Patrick Autocare

Wednesday, 10 June 2015

RE: KEMBLA GRANGE RESOURCE RECOVERY FACILITY

This submission has been prepared by Patrick Autocare (PAC) to address the Response to Submissions Report (Report) prepared by TCG Planning (TCG) on Behalf of Bicorp Pty Ltd and updated Air Quality Assessment by GHD (April 2015). PAC operates the site at 17 Reddalls Road and 66 West Dapto Road as a vehicle storage facility. We remain concerned that the proposal at the Kemplra Grange Resource Recovery Facility (KGRRF) will have unacceptable environmental impacts on staff and operations.

Figure 15 – Predicted – Cumulative PM₁₀ 24-hour Average Concentration (with mitigation) µg/m³

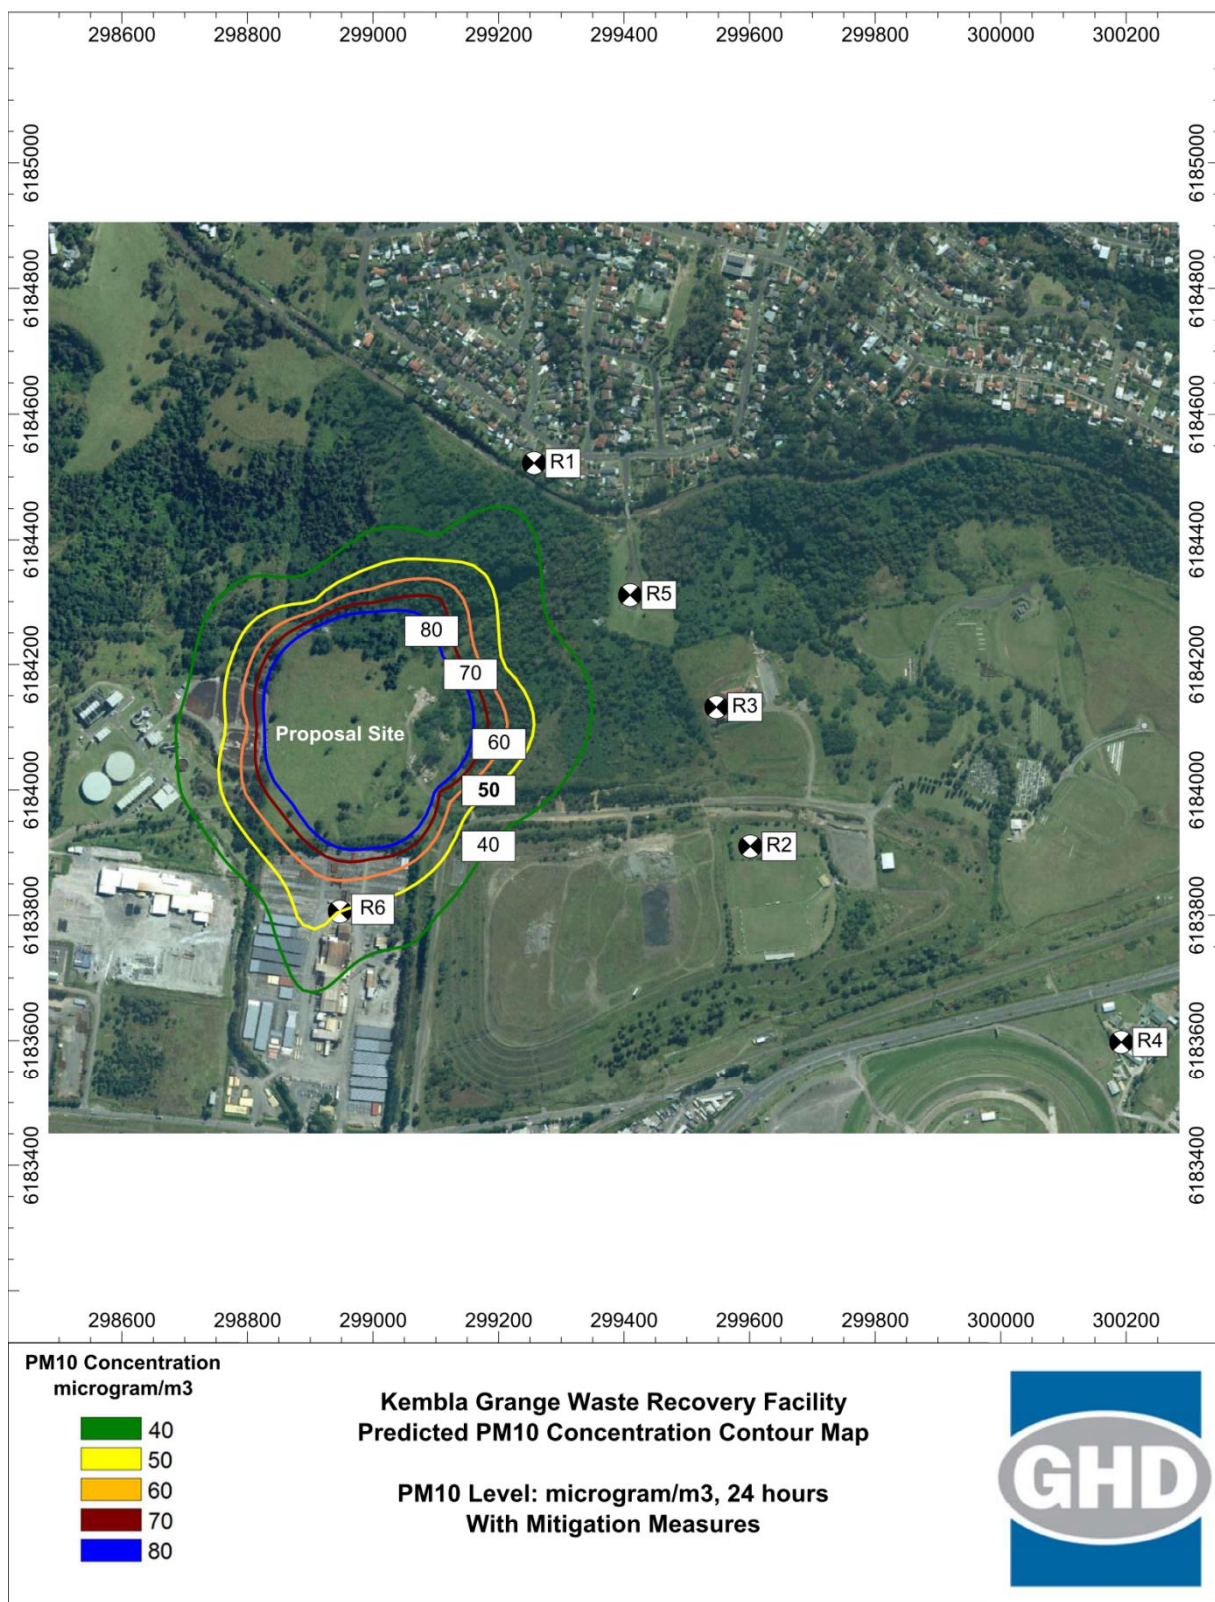
At this location the proposed development is forecast to create a cumulative PM10 impact of 49.3 µg/m³ against an impact criteria of 50 µg/m³. The forecast impact is within 1.4% of the criteria limit.

The borderline PM10 result is confirmed by Figure 15 of the GHD assessment "Predicted Cumulative PM10 24-hour Average Concentration (with mitigation) µg/m³" (included below). The location of the sensitive receiver "R6" appears to be located on the PM10 cumulative impact contour level 50 µg/m³. This contour level defines the area of impact within which the PM10 impact criteria would be exceeded. Had the sensitive receiver R6 been located 10 metres further west or north, Figure 15 shows it is highly likely the criteria would be exceeded. GHD modelled a location on our northern boundary when predicting dust deposition impacts. Had GHD used the same "conservative" assumption for predicting PM10 impacts, it would have exceeded the criteria. We do not have confidence that the Air Quality Assessment's results are valid when the conclusions of the assessment appear to be highly sensitive to variations in the location of the sensitive receiver.

The location of R6 was chosen to reflect the nearest building as stated on page 40 of GHD's assessment "**Note for Patrick Autocare PM10, PM2.5 and TSP have been predicted at the nearest building.**". That building is a relic of previous uses of the site and is not significant to site operations. We consider that the R6 location does not adequately address the worst case impacts on staff and vehicles, with vehicles stored within 30m of the northern site boundary. According to Figure 15 of the GHD assessment, the cumulative PM10 concentrations will exceed the 50 µg/m³ limit across the northern end of the site and will exceed 80 µg/m³ along parts of the northern site boundary. Consequently it would be more appropriate for sensitive receiver R6 to be placed on the northern boundary. This would be consistent with the location used for dust impacts and would require the applicant to demonstrate that all the areas of the site where our staff work and vehicles are stored will not be impacted beyond the criteria limit.

Figure 17 – Predicted –Annual dust deposition (with mitigation) $\text{g/m}^2/\text{month}$

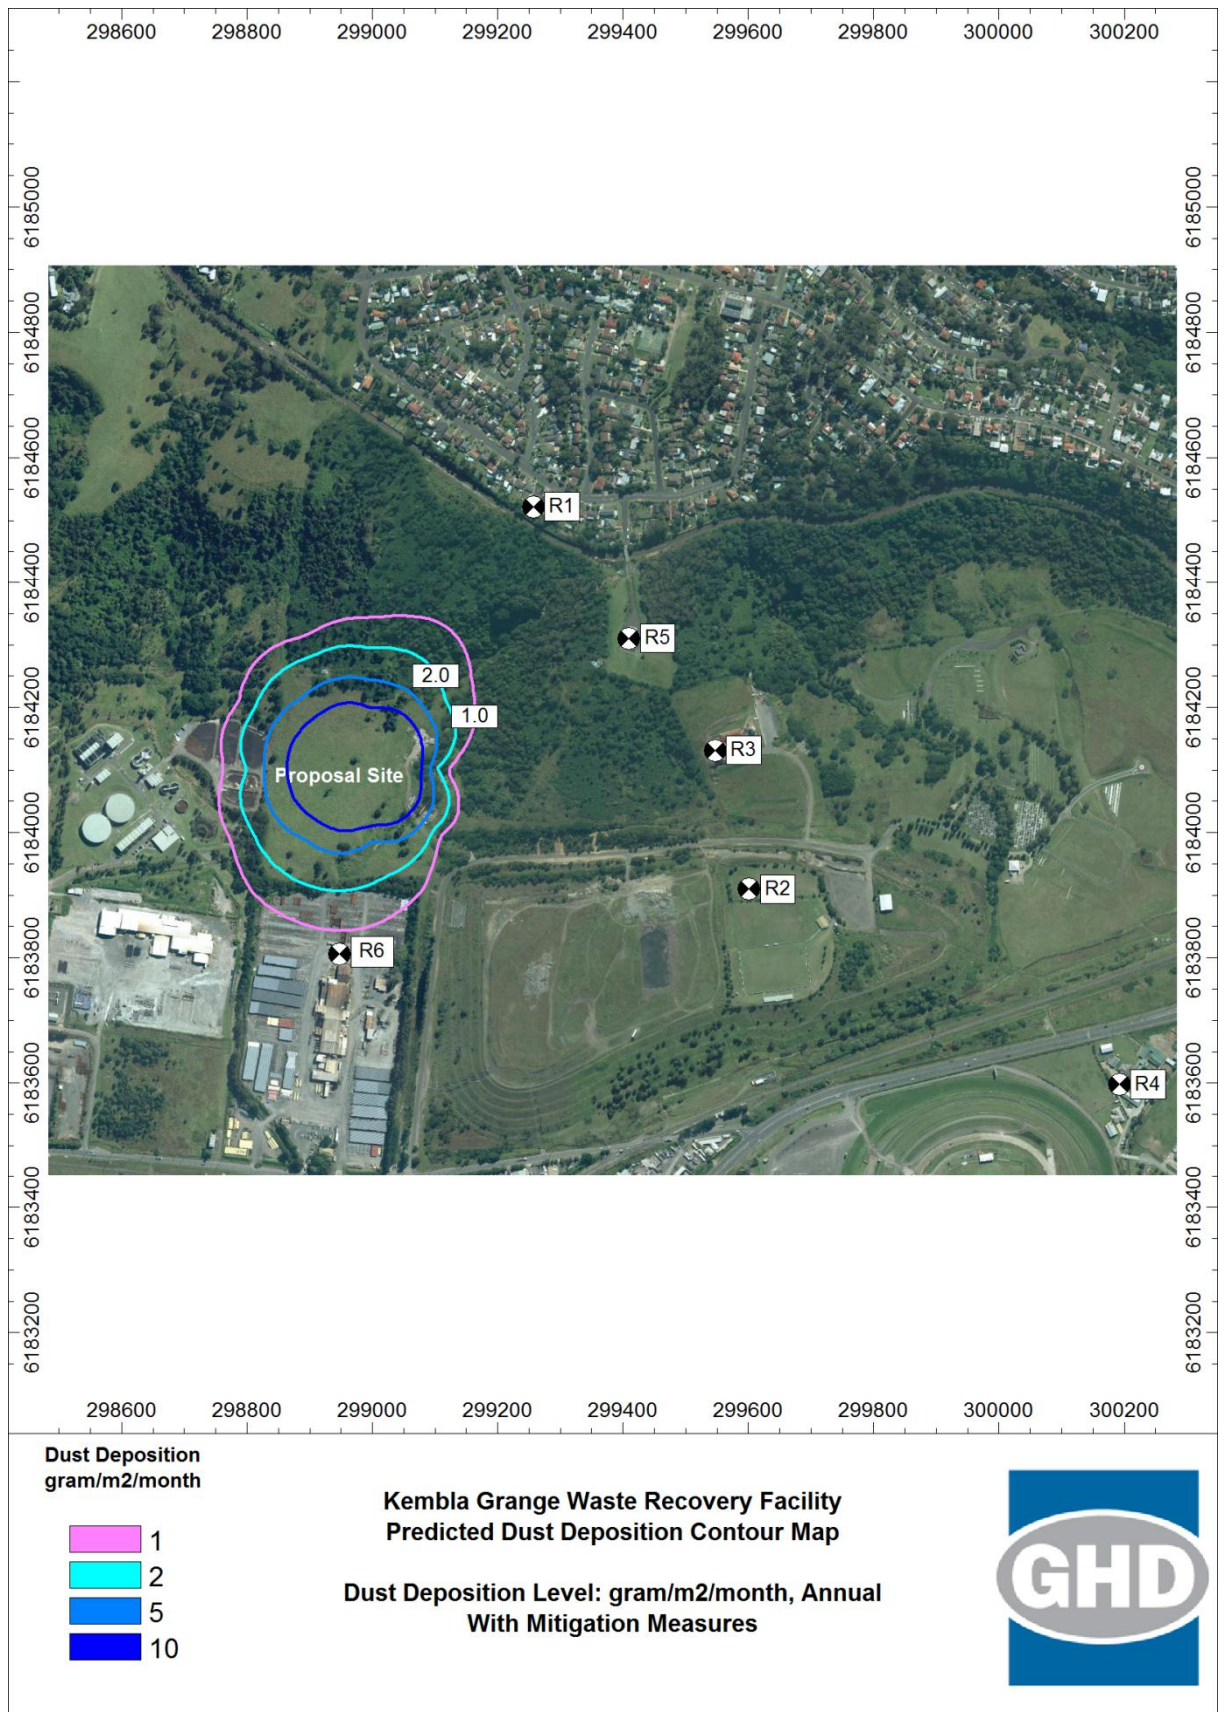
However Figure 17 of the GHD assessment *"Predicted Annual dust deposition (with mitigation) g/m2/month"* (included below) shows the location of the PAC Sensitive Receiver "R6" on the northern end of the site's building. The location of the dust receiver identified in the text as being on the northern property boundary is not shown. To provide clarity the location of both receivers should be shown on Figure 17.

Figure 19 – Predicted Peak Odour Contour Map, OU with building ventilation

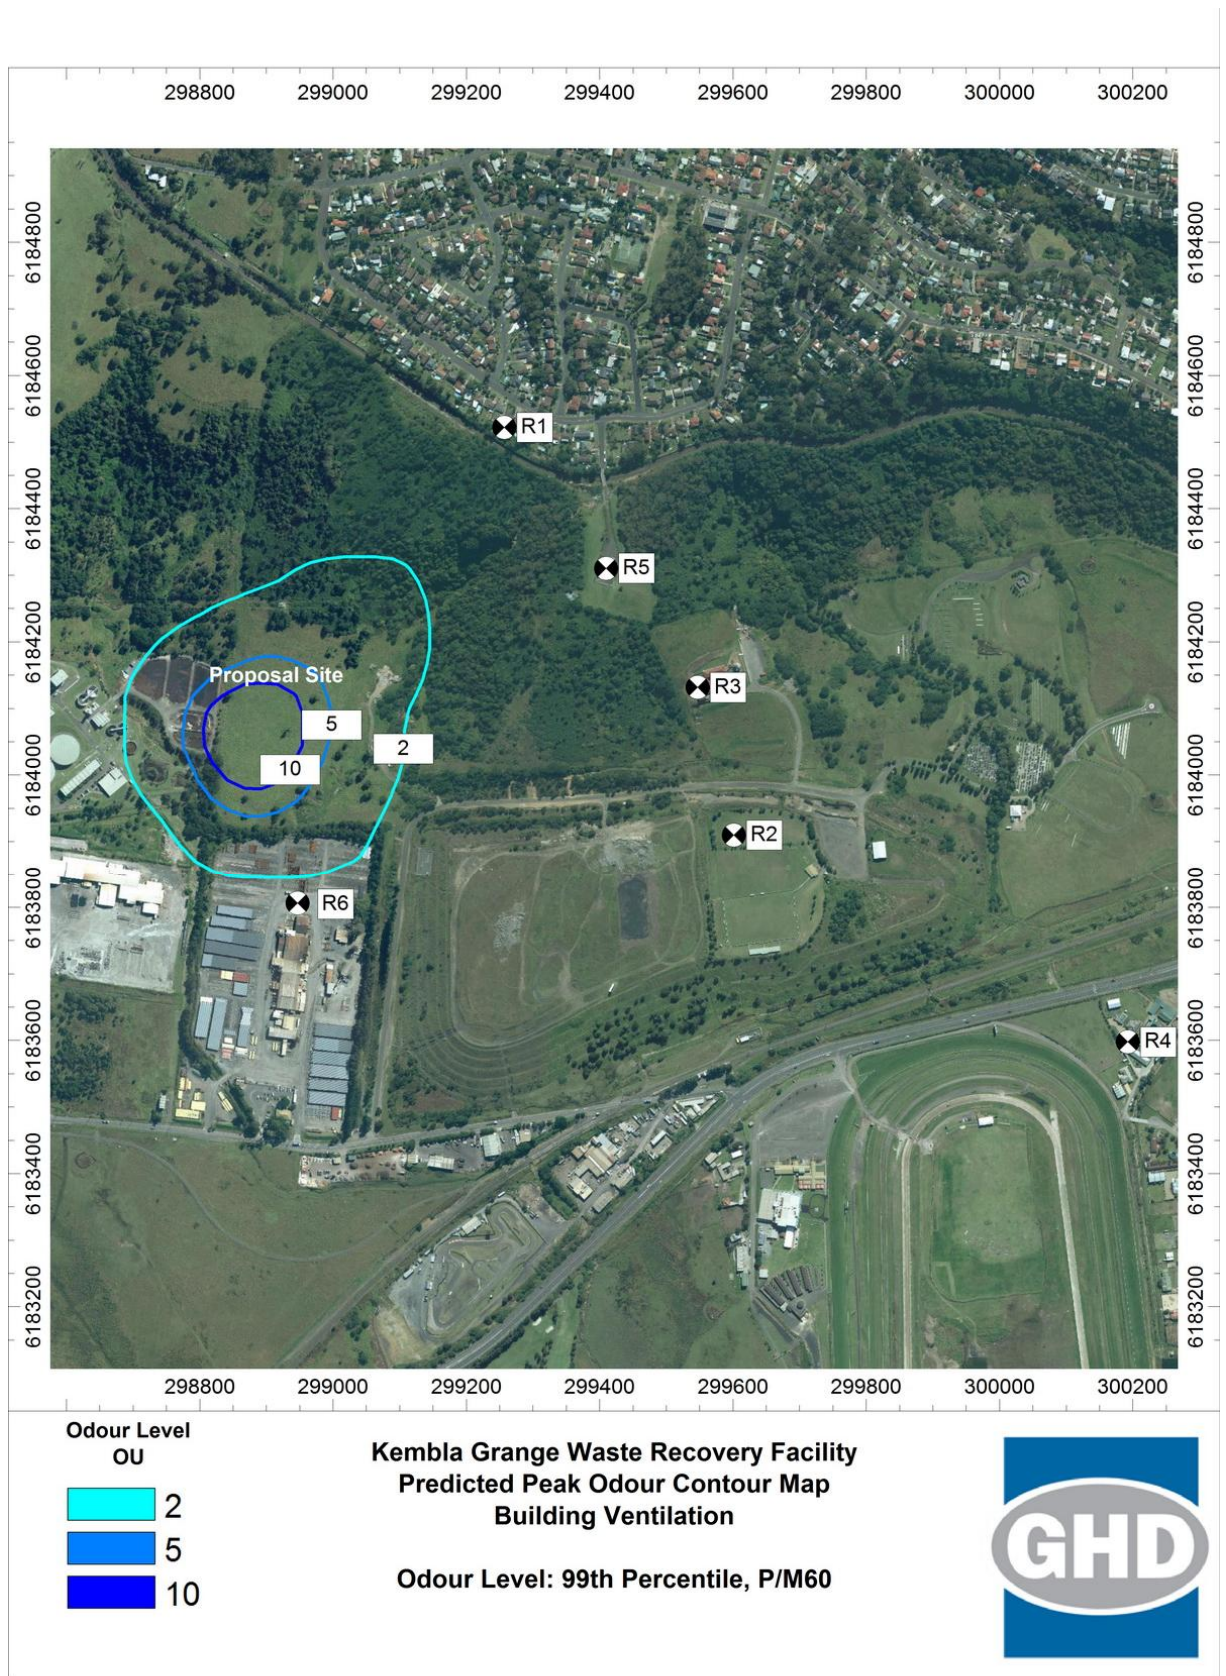
The GHD air quality assessment does model our site via sensitive receiver R6 located north of the buildings on site. However, as noted above this location does not reflect the greatest potential impact likely to be experienced by the work force and vehicle stock on the site. Figure 19 of the GHD assessment "Predicted Peak odour Contour Map, OU with building ventilation" (included below) indicates that the 2 OU criteria limit will be exceeded on our site within approximately 100 metres of the northern site boundary.

Consequently, a sensitive receiver location at the northern boundary would be more appropriate and provide a more conservative assessment requiring the proponent to modify their proposal so that the entirety of our site will not suffer odour impacts beyond the limits specified in the air quality criteria.
